CITY OF ALBUQUERQUE

Re: Center for Prenatal Development Grading and Drainage Plan
Engineer's Stamp dated 5-8-06 (G17/D42)

Based upon the information provided in your submittal dated 5-26-06, the above referenced plan cannot be approved for Building Permit until the following comments are addressed:

A1 OVERALL GRADING PLAN
SCALE: 1" = 20'-0"

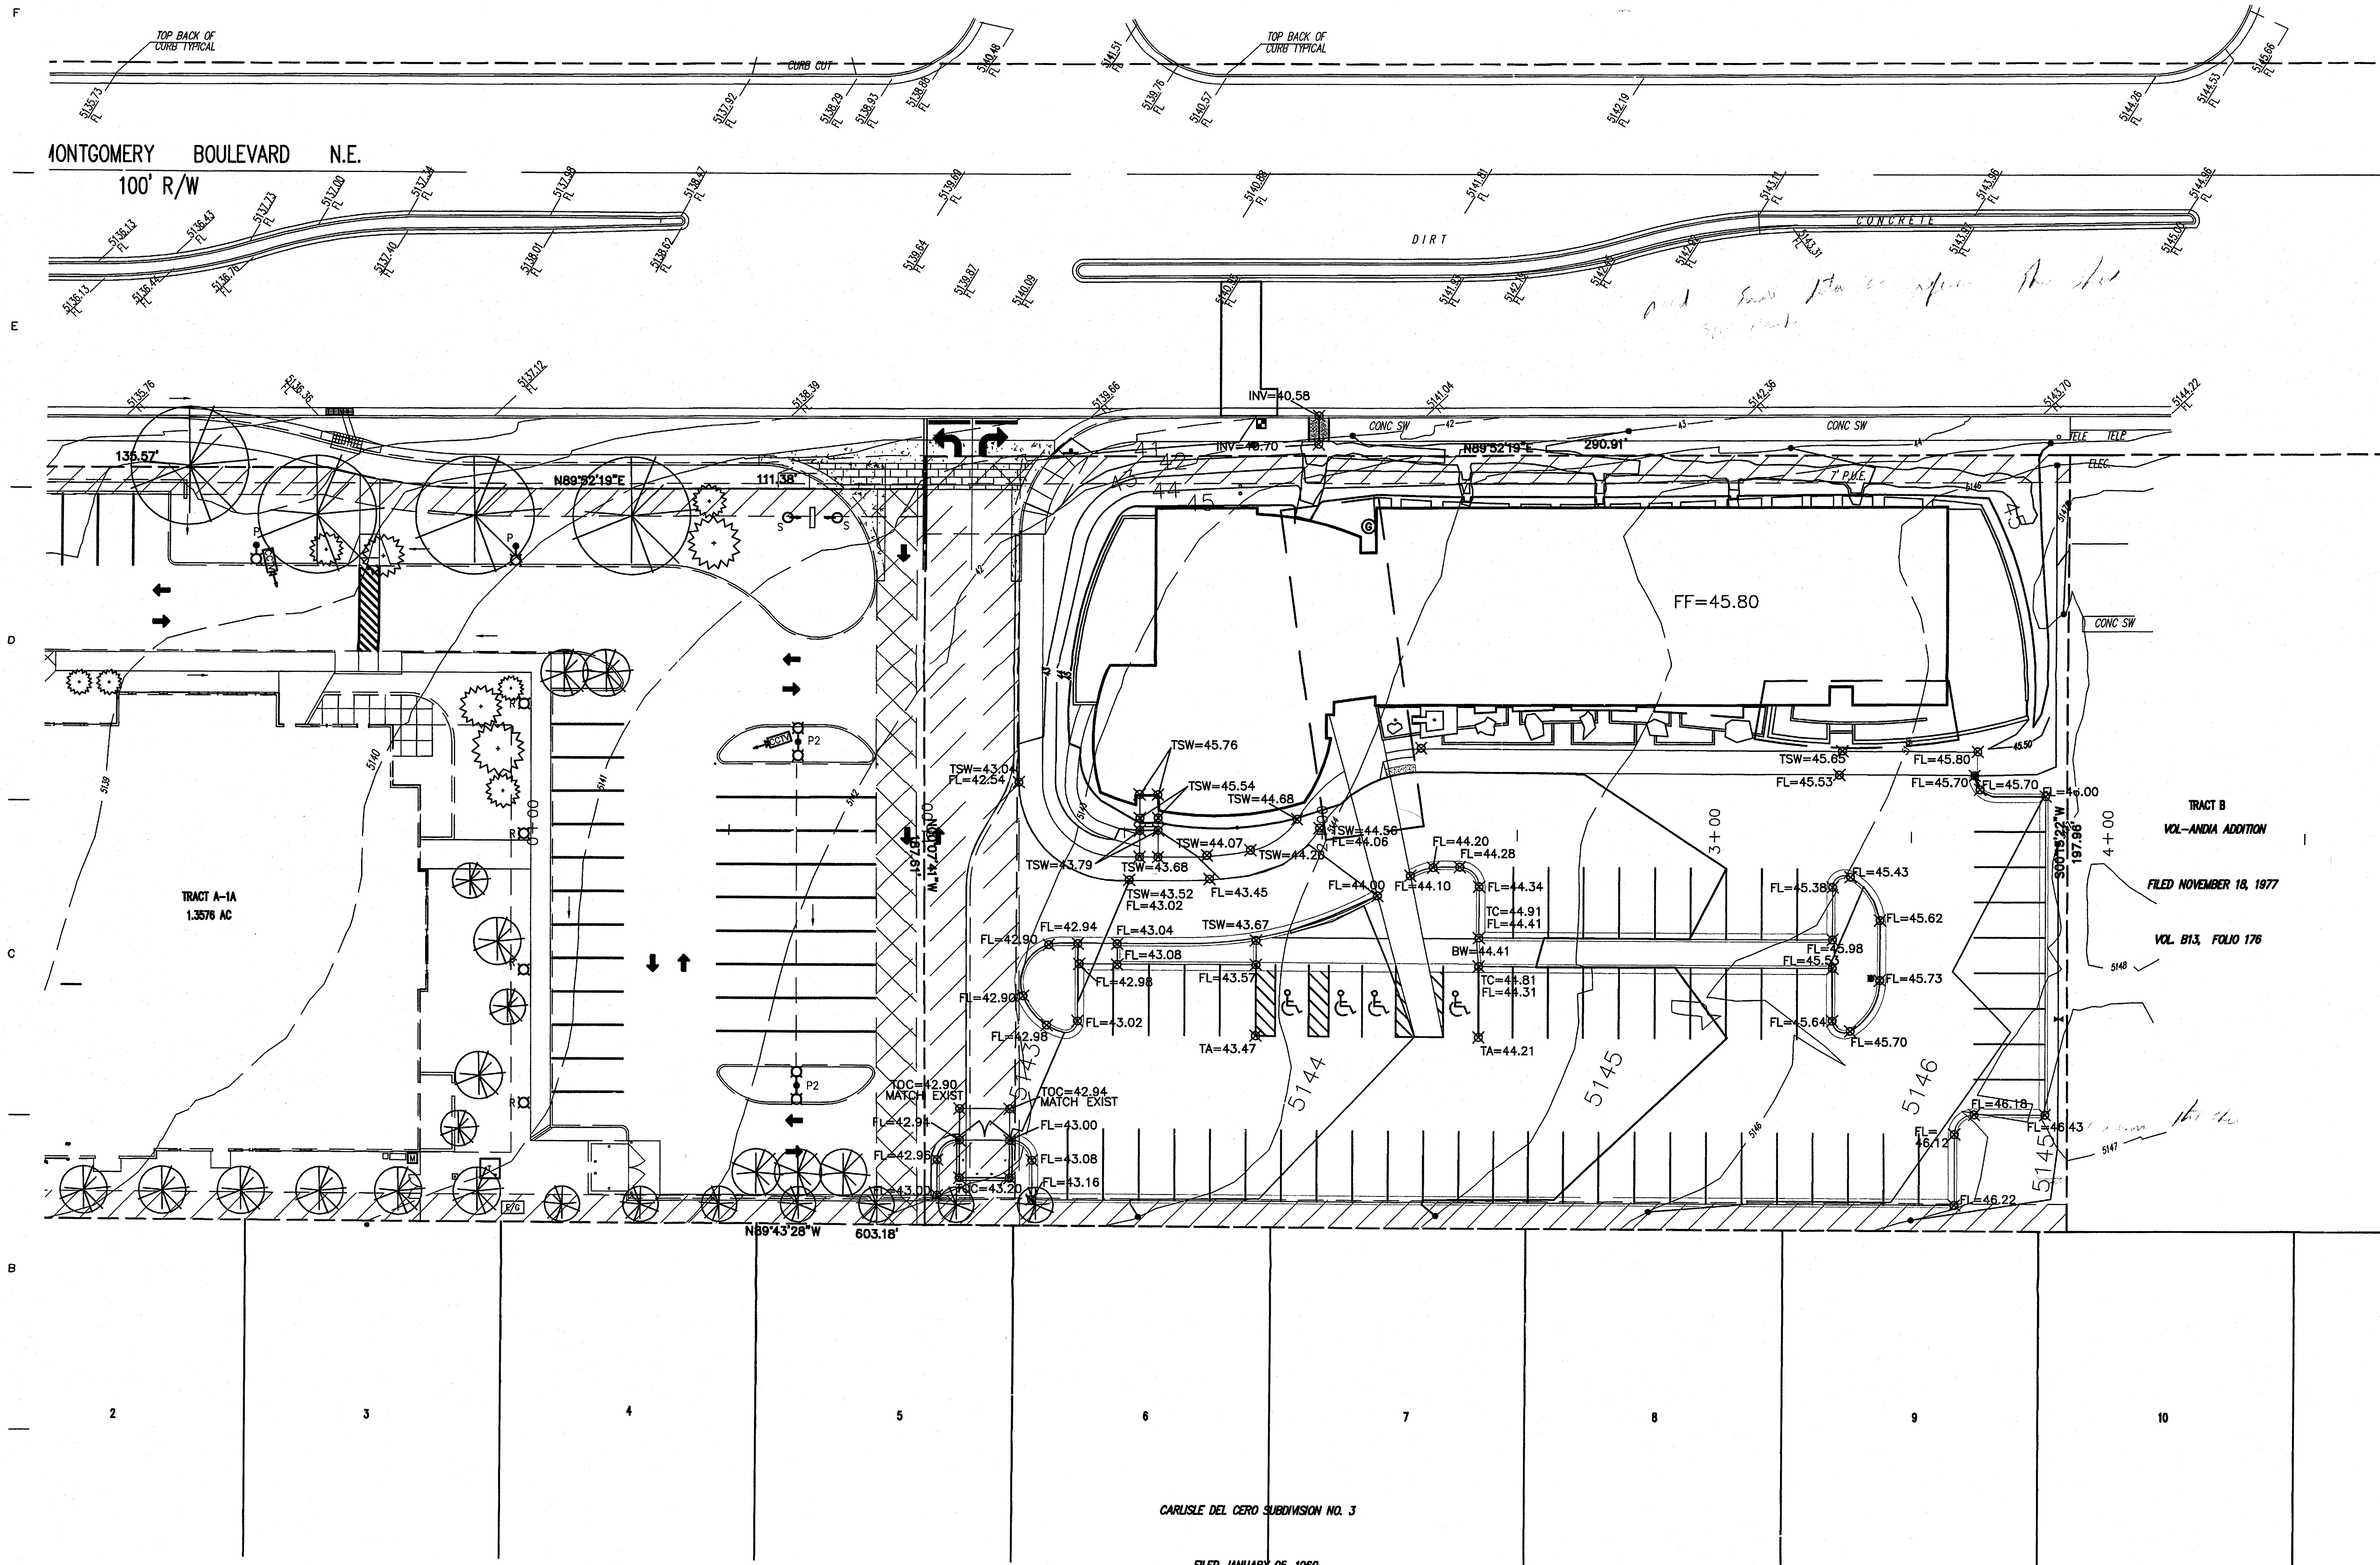
- ✓ Specify COA standard drawing 2236 for the sidewalk culvert including the width.
- ✓ Provide a detail of the conveyance for Basin Off #1.
- ✓ Include SO19 notes on the plan. See attached.
- ✓ Provide a legend for hatched areas.
- ✓ Add a note to remove the existing curb.
- ✓ The FF elevation is different on different sheets. What is the FF elevation?
- ✓ Provide a typical section of the swale North of the building.
